## About the application

Application number: 2025/90768	
What is the application for?:	Erection of detached dwelling and associated external works
Address of the site or building:	Land Adj, 2, Hopton Hall Lane, Upper Hopton, Mirfield, WF14 8EP
Postcode:	WF14 8EP

## User comments

EAST ELEVATION
1:100

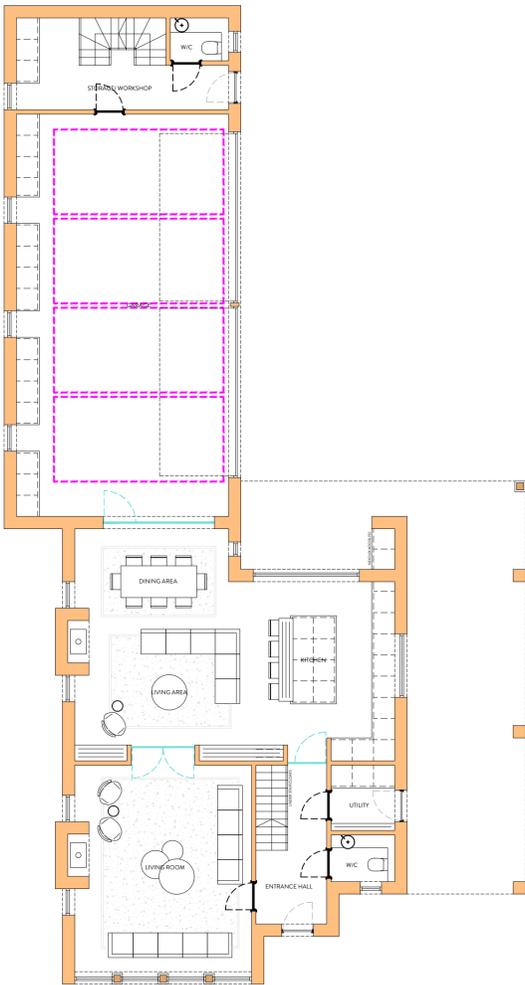
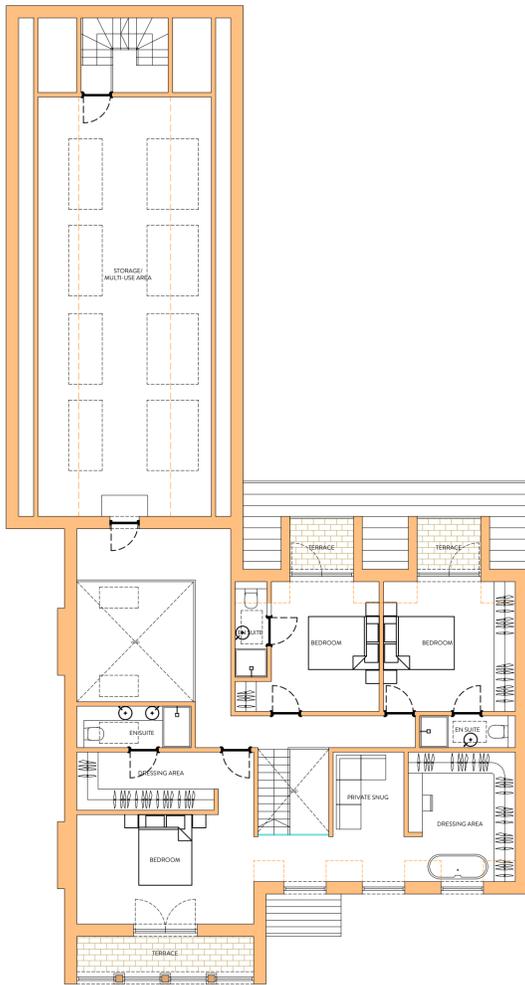
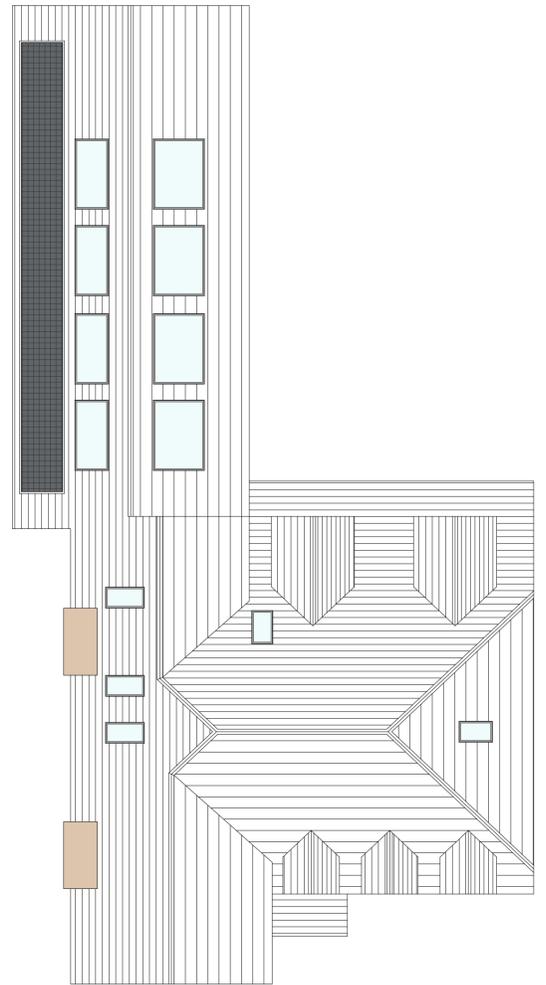
Type of comment: An objection	
Do you wish your comments to be published on the website anonymously?	Yes
<p>The relatively small changes to the original rejected application have done almost nothing to reduce the overpowering size of the proposed application. This is still out of character with the surrounding buliding as are the proposed buliding materials. It will still dominate the view from all sides.</p> <p>Although apparently only three bedrooms the large open space above the garage and called a storage area on the plans could easily be converted into bedrooms at a later stage thus increasing the number of occupants of the house and inevitably adding more traffic to the already busy hopton lane. At present the garage and parking spaces appear verylarge for a planned three bedroom house.</p> <p>The effect on traffic on hopton hall lane has already been commented on in the previous rejected application</p> <p>It would also appear that the new building would still overlook the existing dwellings at 2 hopton hall lane, 5 chiltern drive and possibly the ones on Fairways</p>
